From: Andrew Wood
Sent: 10 May 2019 10:15
To: Planning.Responses
Cc: Juan Baeza
Subject: FW: Planning application ref. R/34/19/PL - 4 Broadmark Parade, Rustington
Attachments: Rustington - 2940- PL125B Proposed Roof Plan-PL125.pdf; Rustington - 2940- PL211C Proposed External Elevations-PL211.pdf

As requested please find revised drawings nos. PL125 Rev. B (superceding previously submitted PL125 Rev. A) and PL211 Rev. C (superceding previously submitted P211 Rev. B) detailing screening around the flat roof of the proposed rear extension to minimise any further impact.

proposed side elevation C
scale - 1:50 @ A1 / 1:100 @ A3

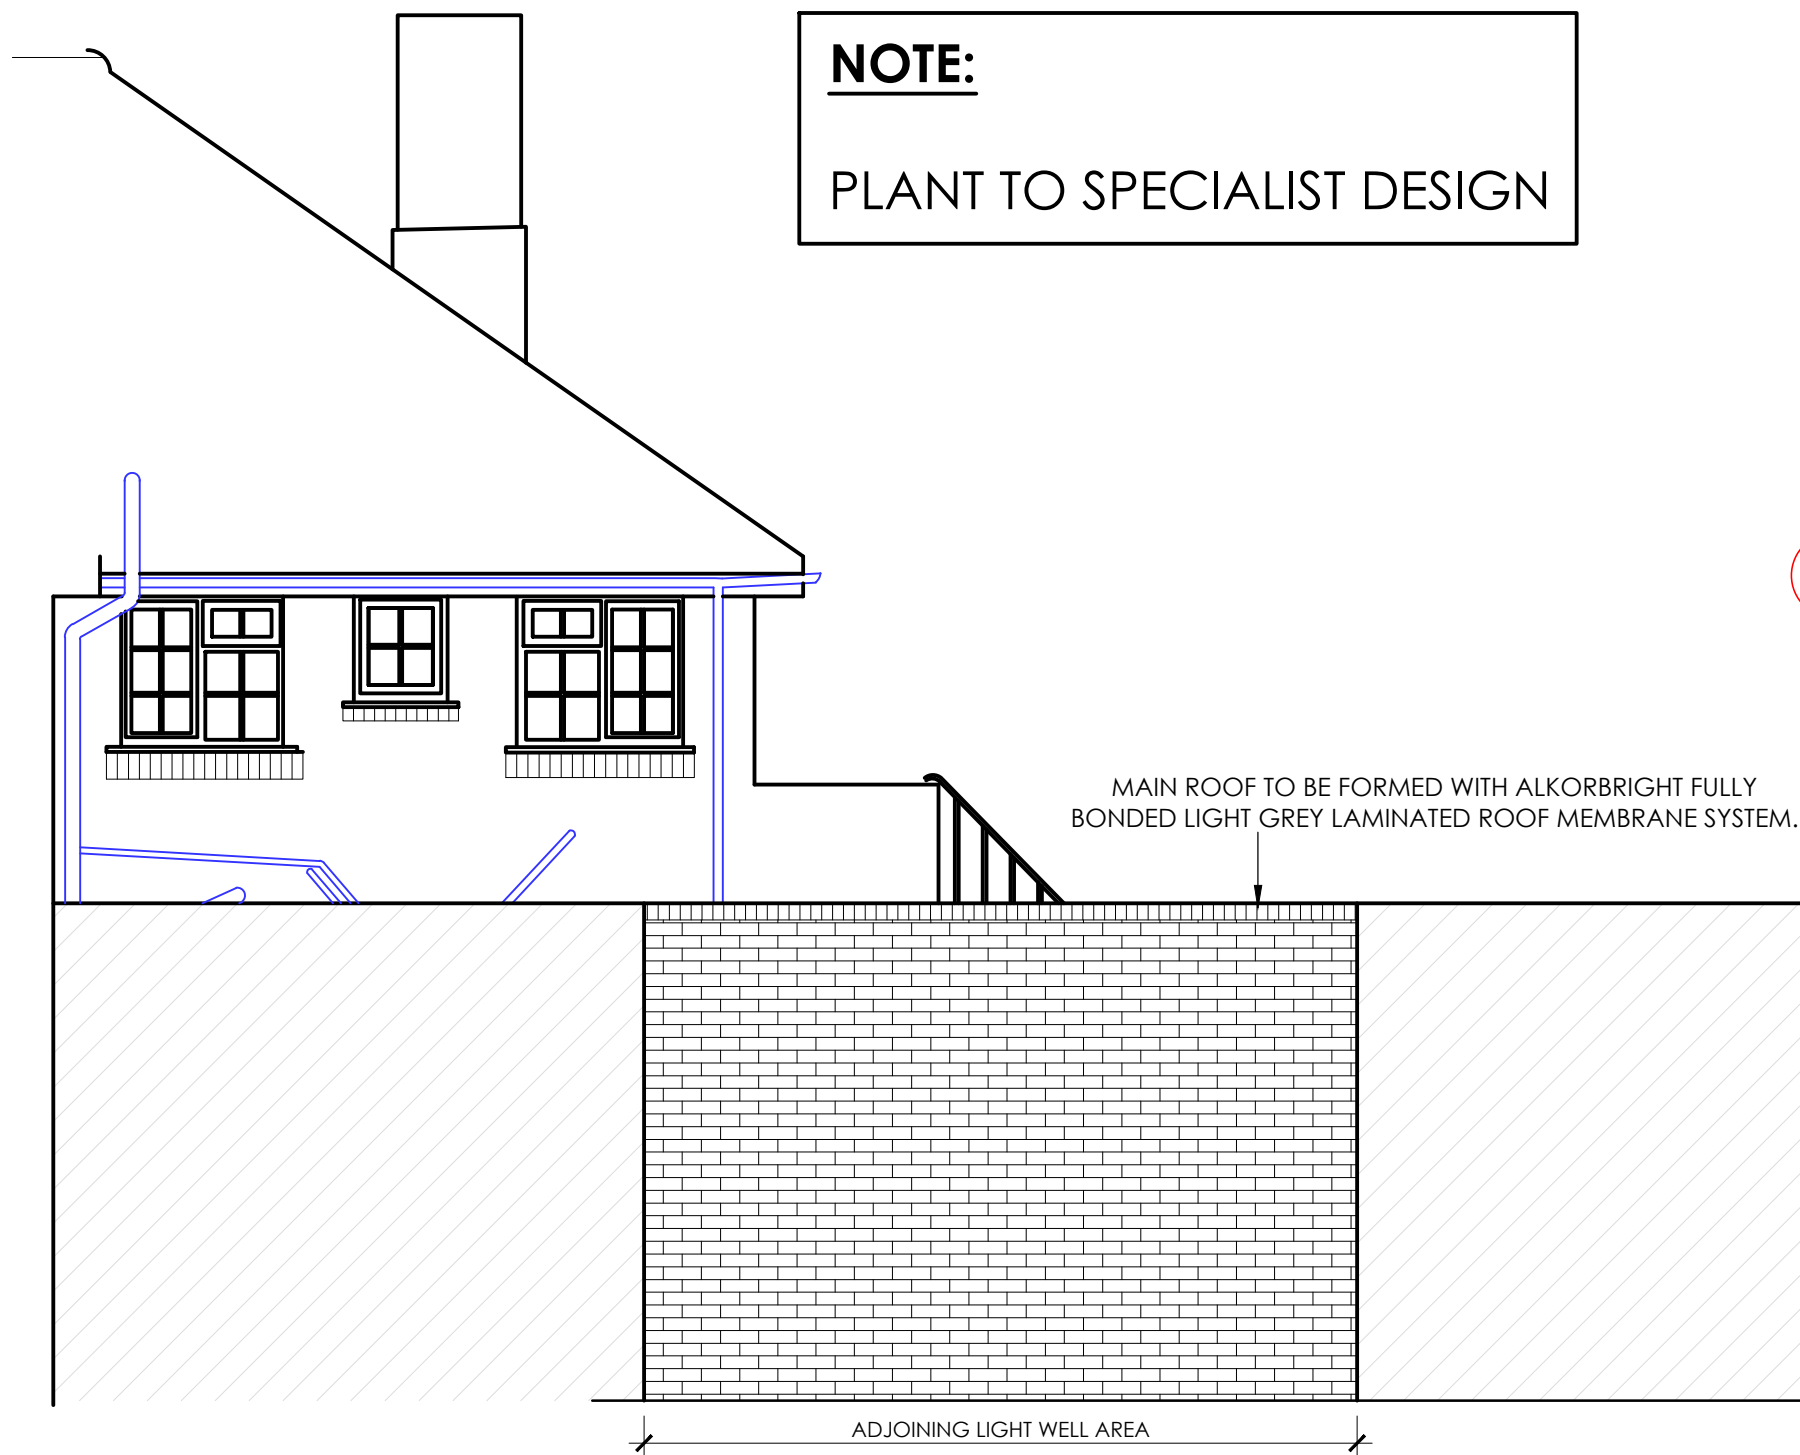
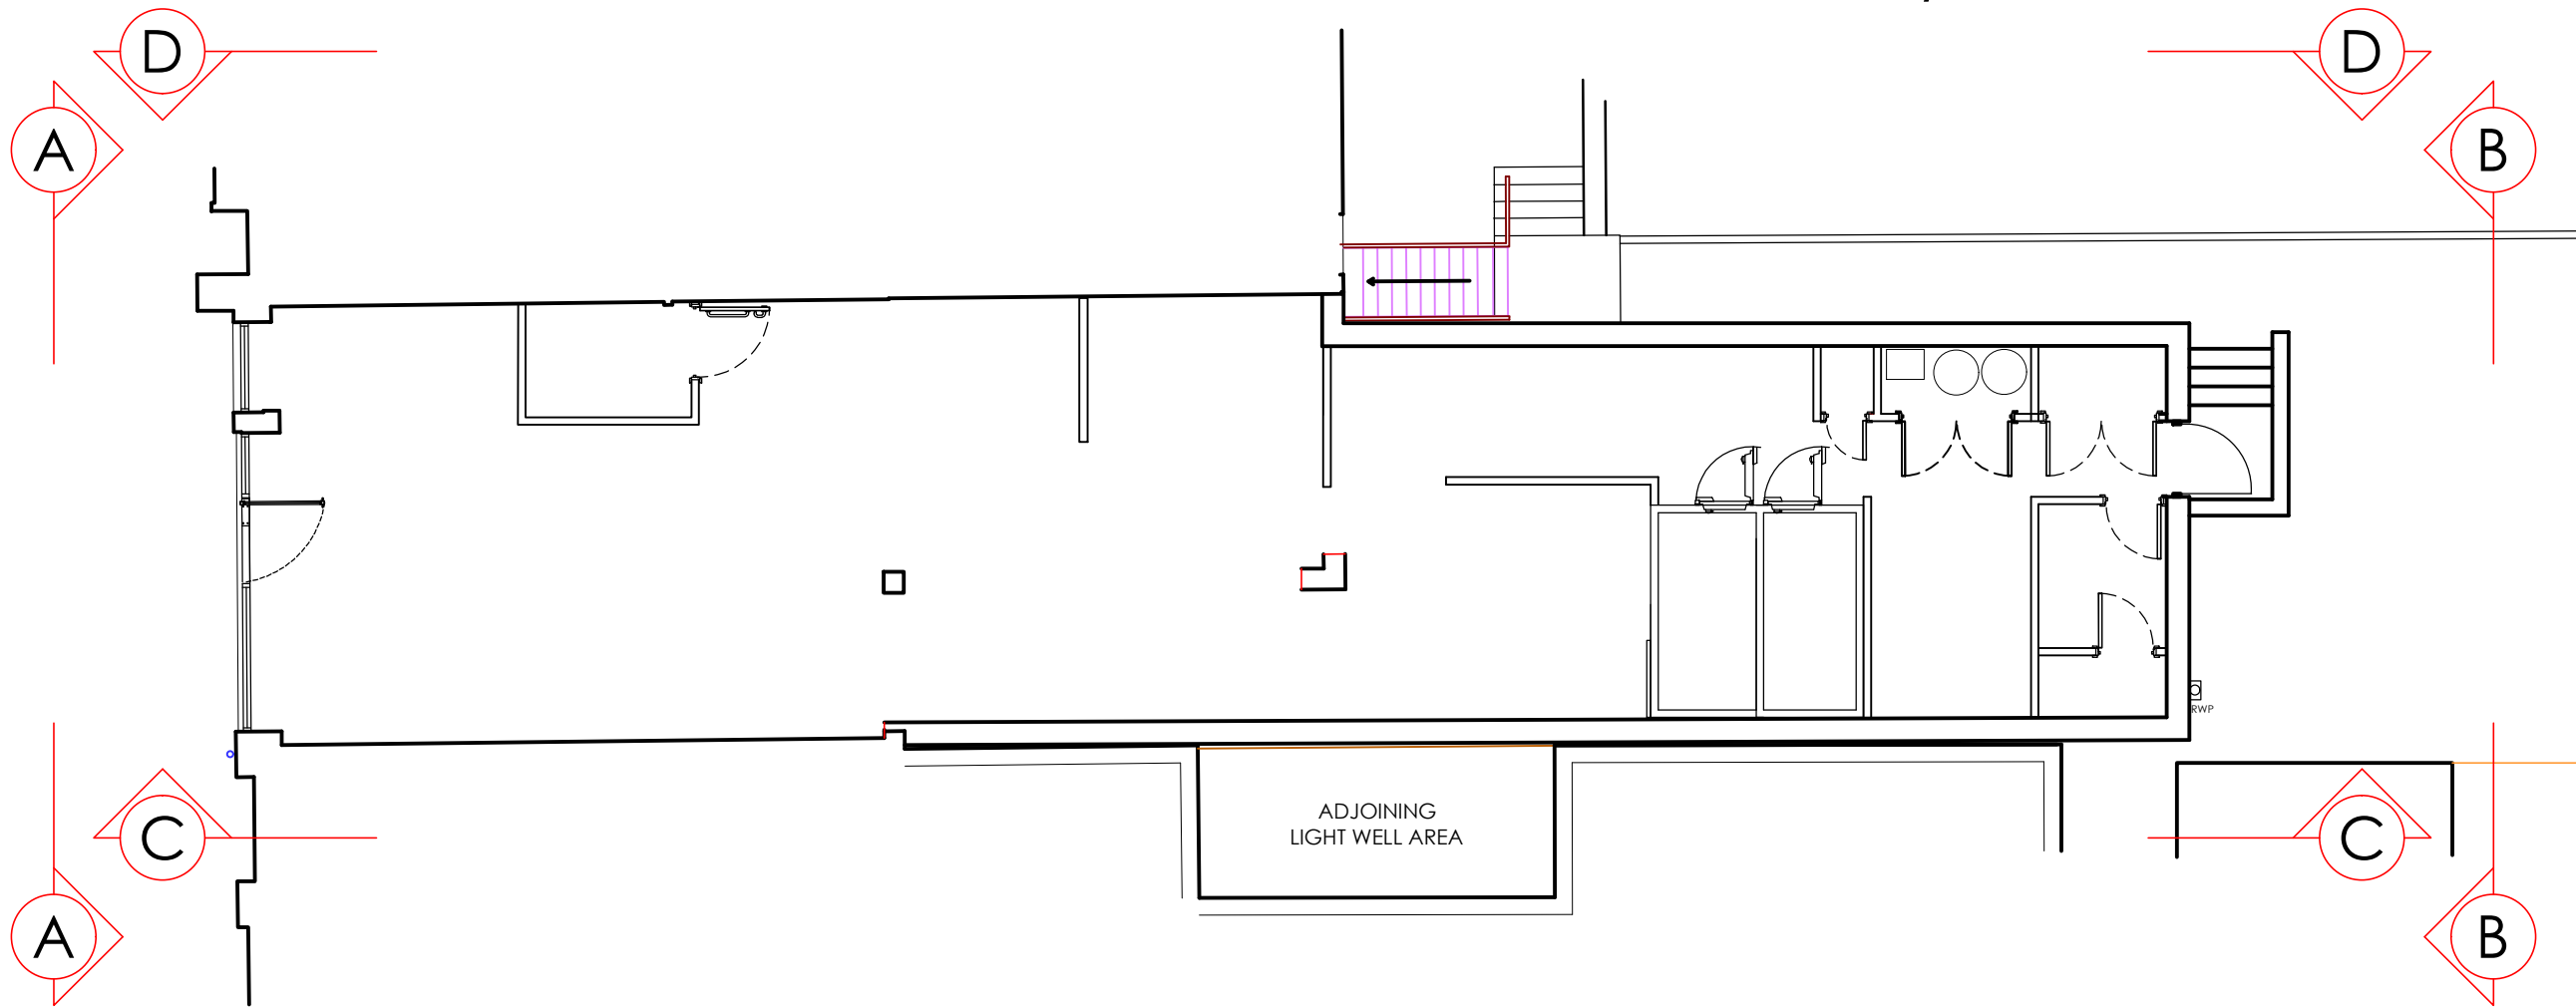
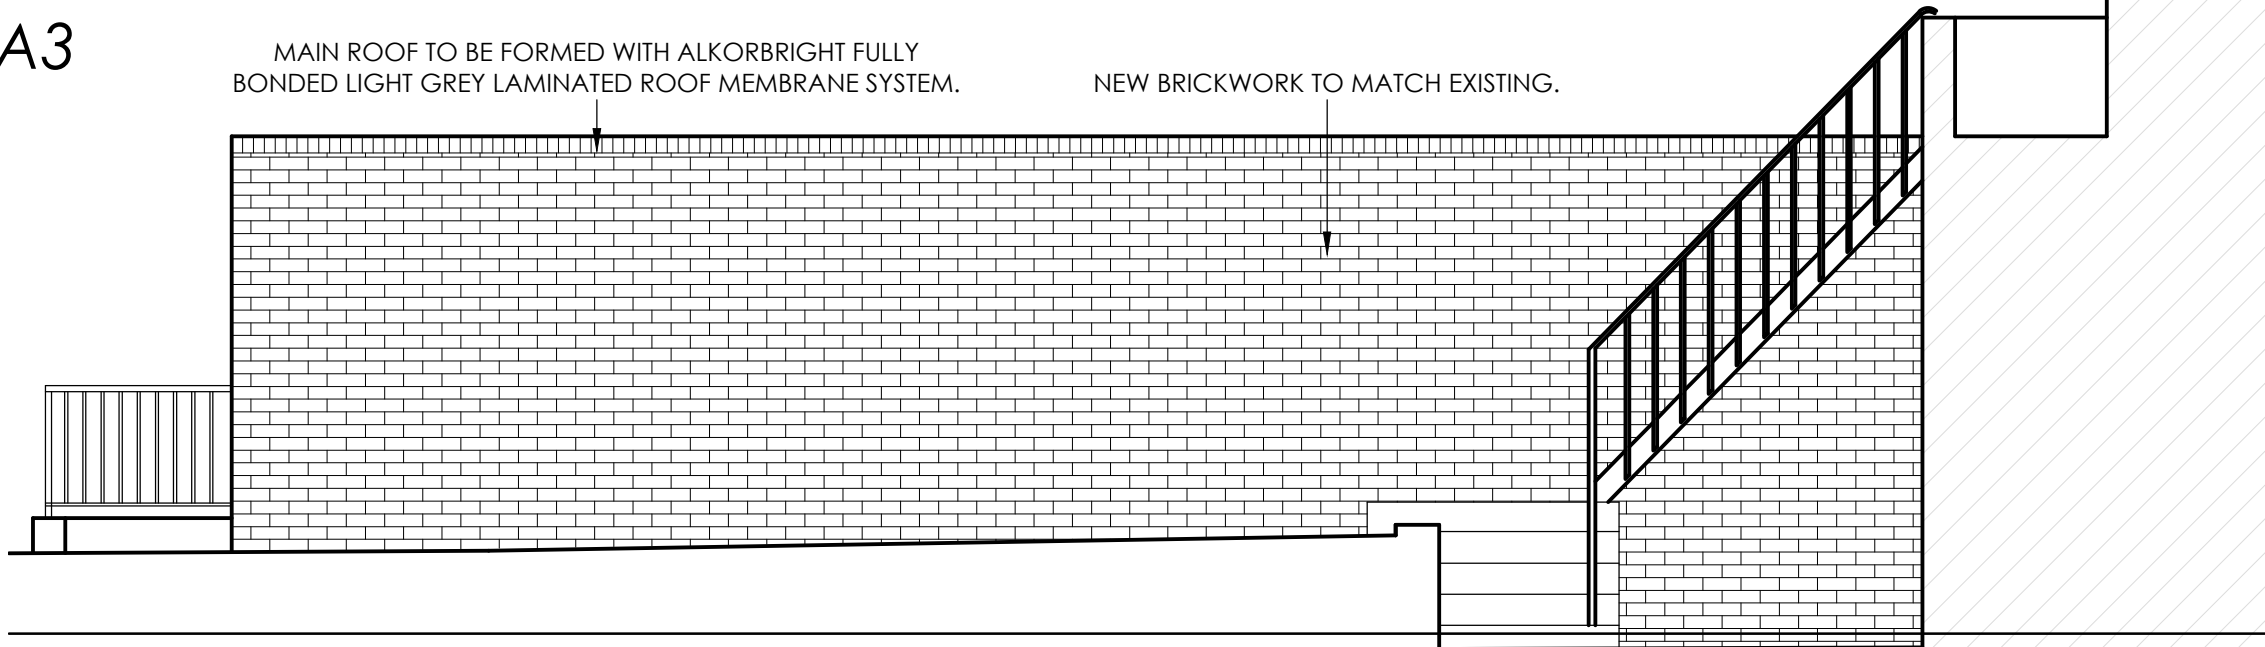
In the meantime would you mind submitting a further plan showing some kind of visual protection to the roof of the rear extension from the various air cooling and odour removal systems.

While I would acknowledge that the site is commercial in nature there are residential properties above the shops and wider views within the townscape for users of the Waitrose car park who access the high street via the alley close by as well as residential properties 60/70 metres away.
